COUNTY FILE NO. PPR-17-056/ESQ-17-037

**MASTER BLASTER**  
 GBP LOT 35-2  
 1259 COLE VIEW  
 COLORADO SPRINGS, CO 80915  
 EL PASO COUNTY, COLORADO

1 of 8  
 SITE PLAN

# Markup Summary

1 SITE PLAN
SCALE: 1"=20'-0"

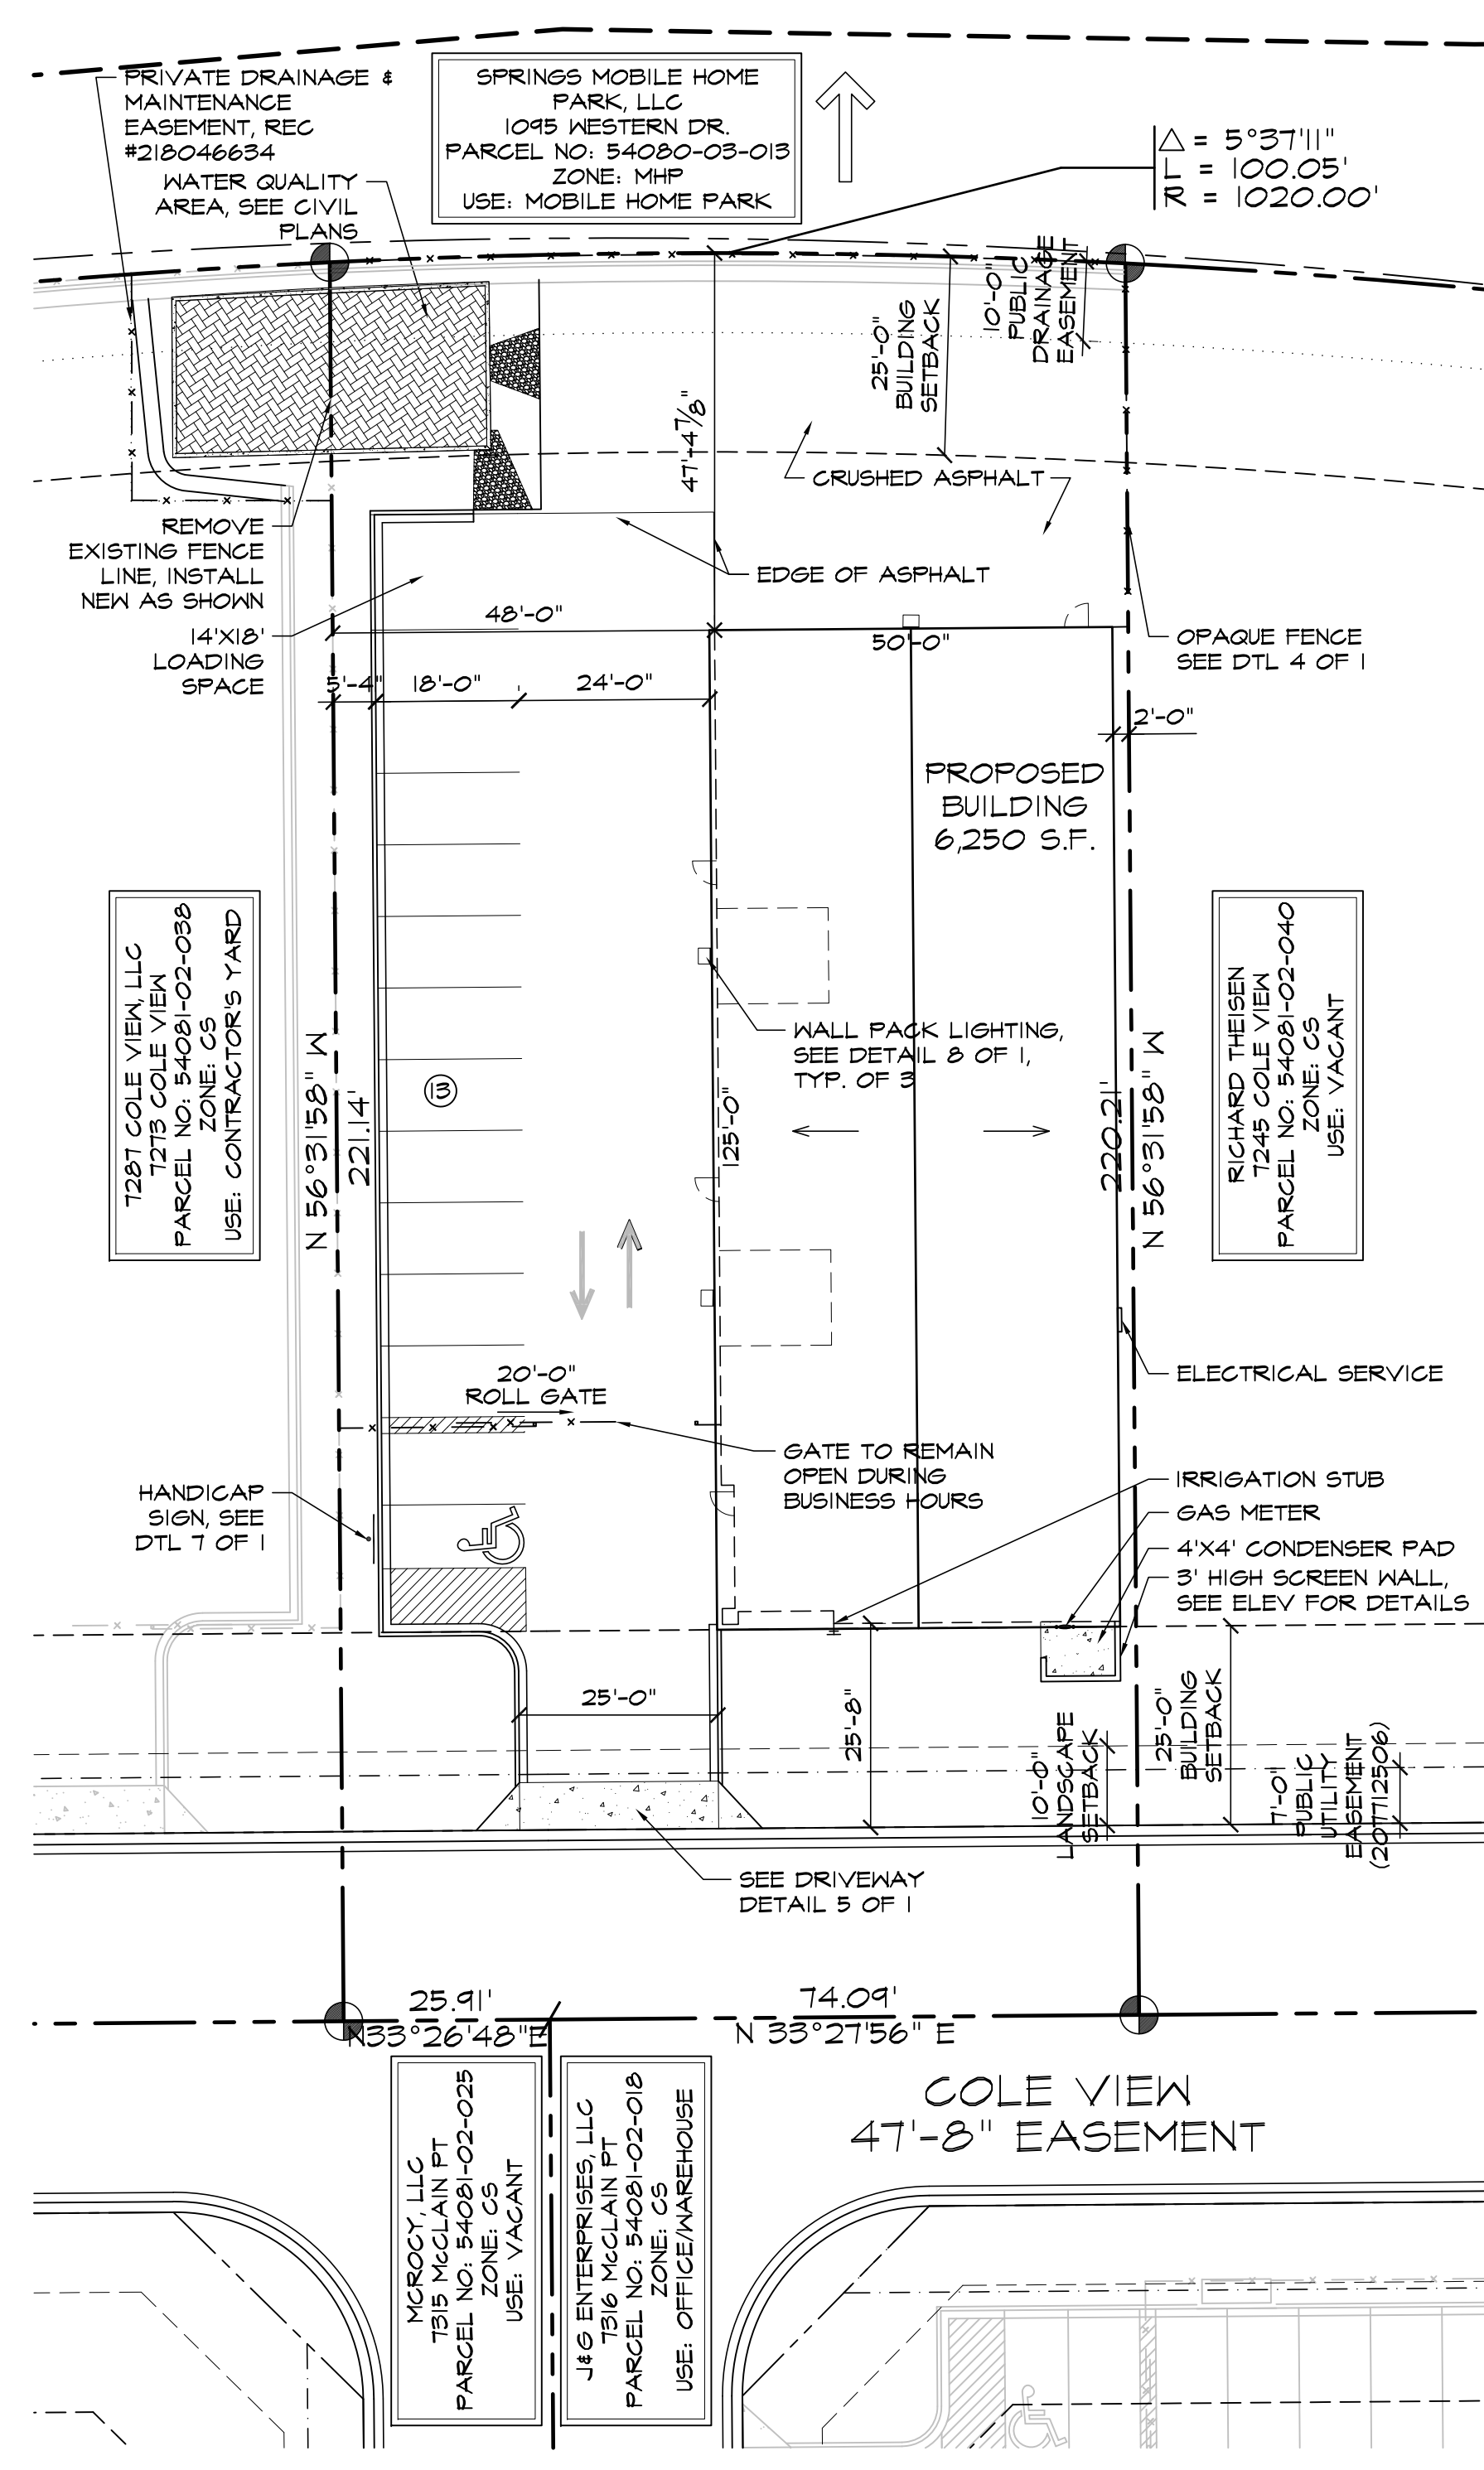
The applicant must obtain a permanent drainage easement from Lot 34. The County will require a copy of the recorded document. The agreement between Lots must outline the maintenance responsibility for the permanent facility.

Show the easement (w/ bearing & distance label) on the site plan with reference to the reception number of the recorded easement agreement.

If the plan is to remove this section of existing fence, then callout as such in the site plan.
